Application for a non-material amendment following a grant of planning permission.
 Town and Country Planning Act 1990

Conversion of Agricultural Barn into Dwelling House

PF/17/0068 + RV/23/1005

Drwg. Title **Plans and Elevations as Proposed**

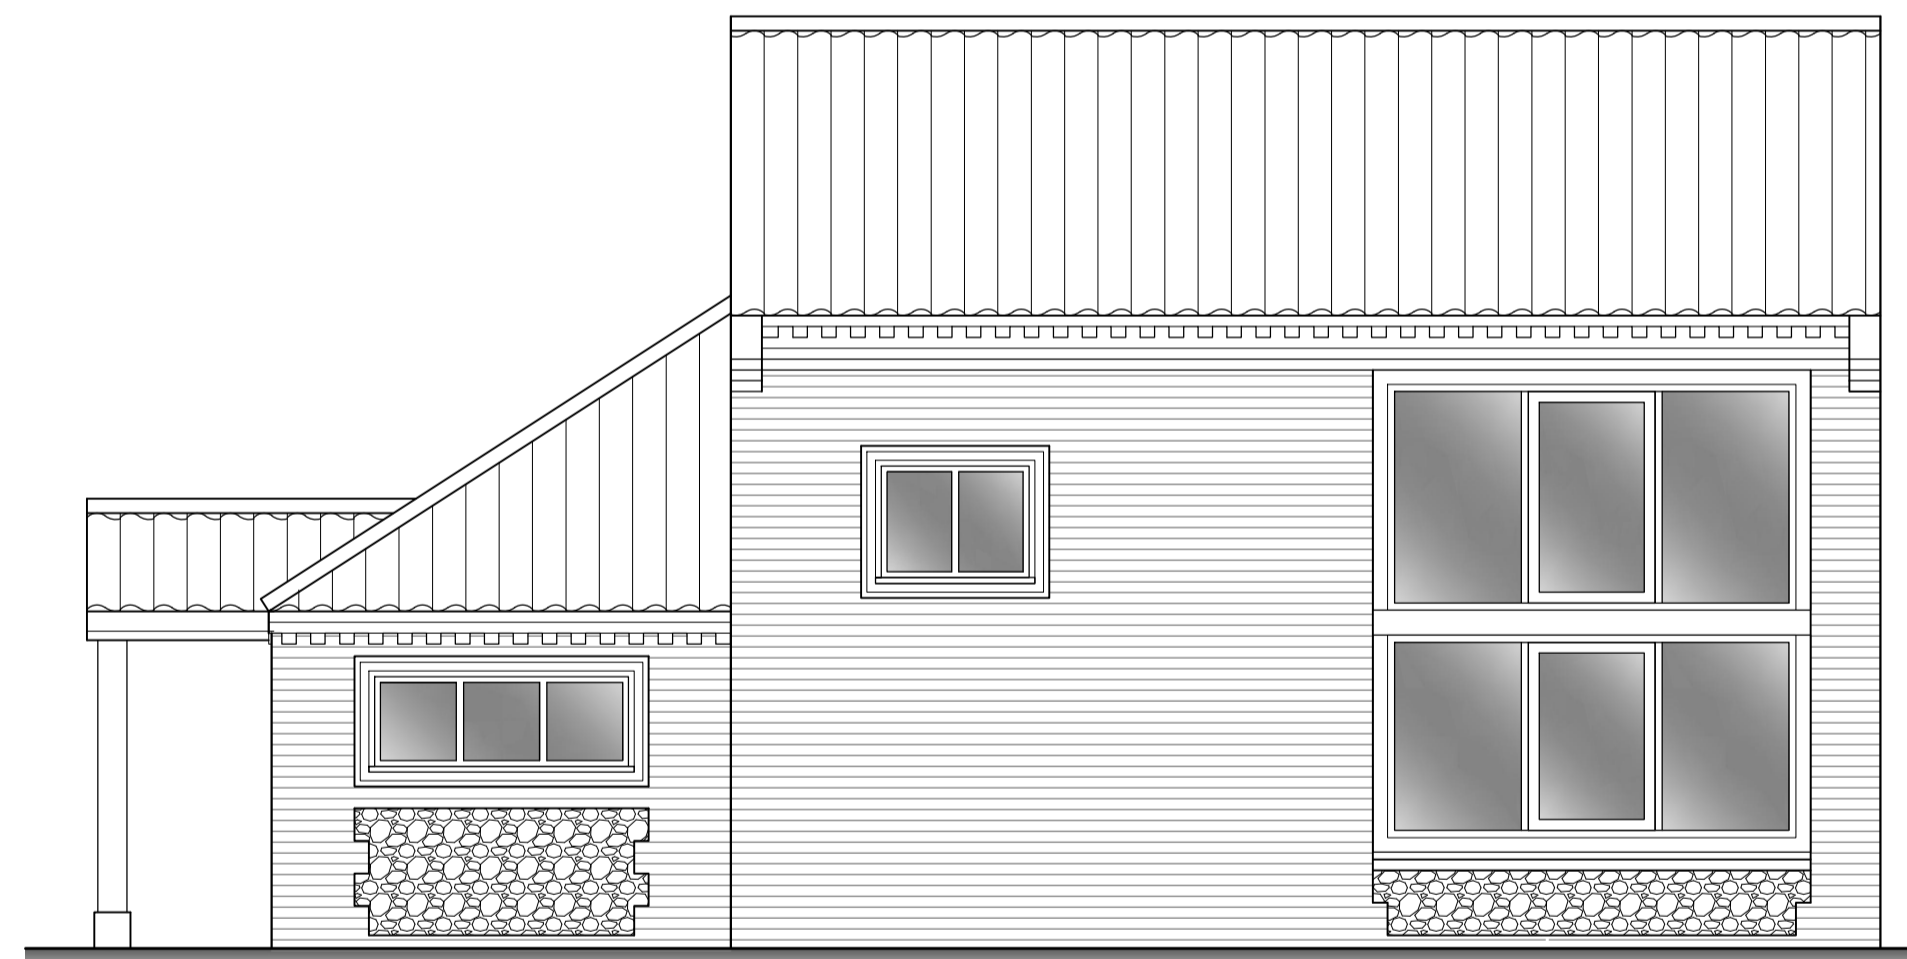
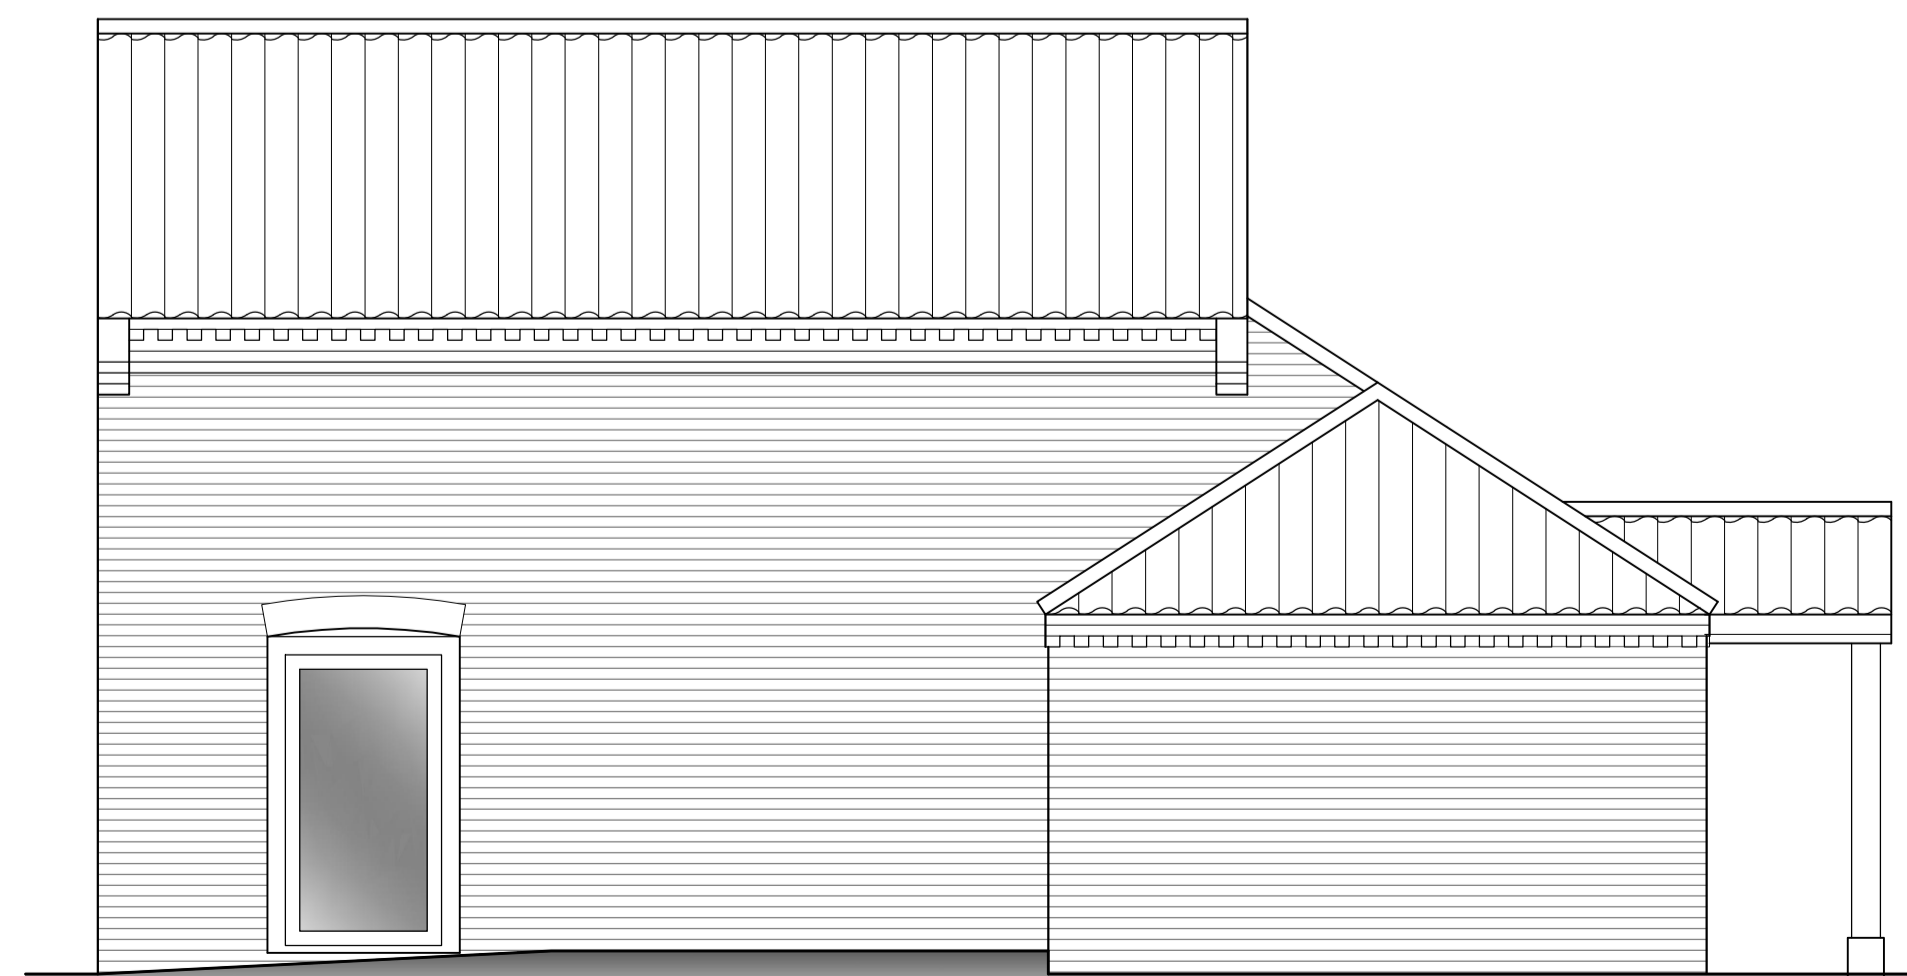
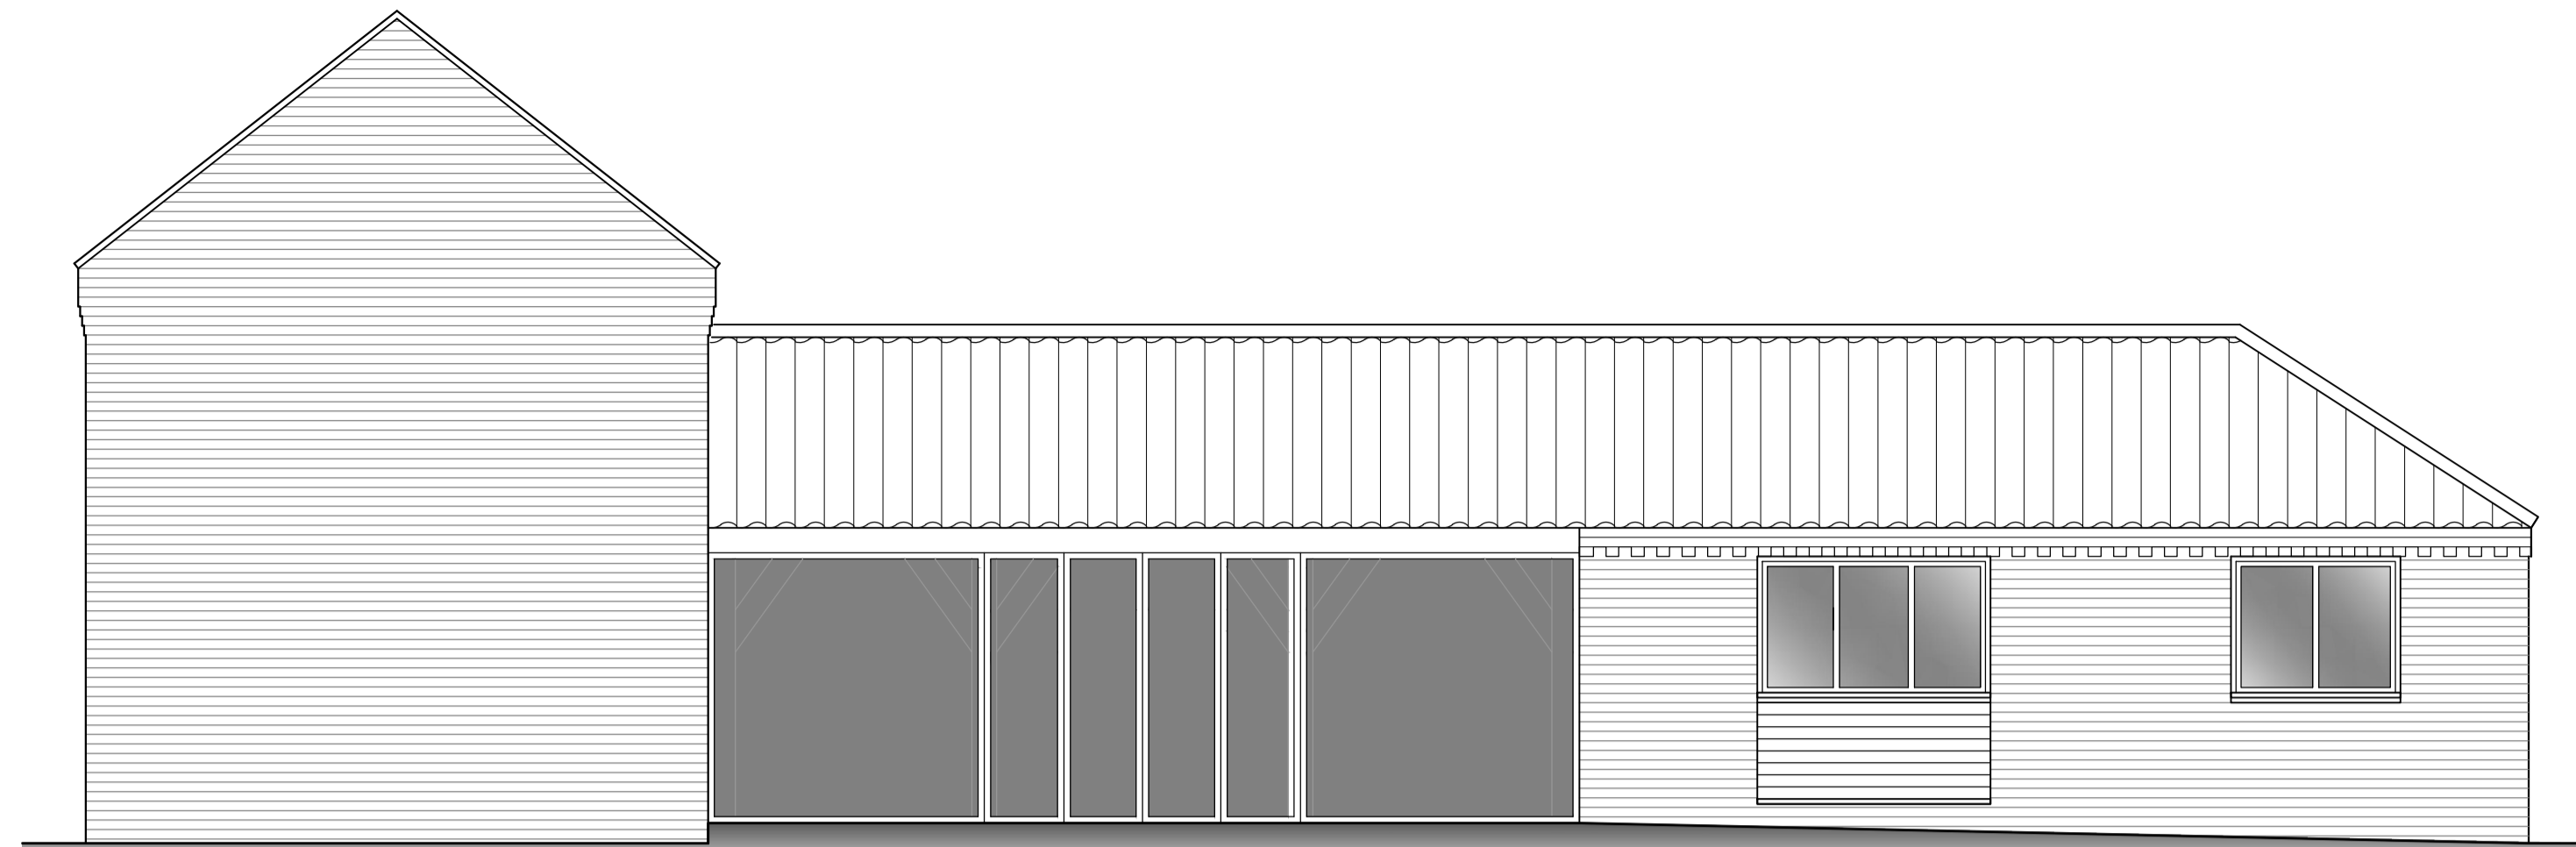
First Floor South Windows to North Elevation.
Caddy South Window to West Elevation. New Window
in North Elevation. Redlight Removal from First
Floor Bathroom.
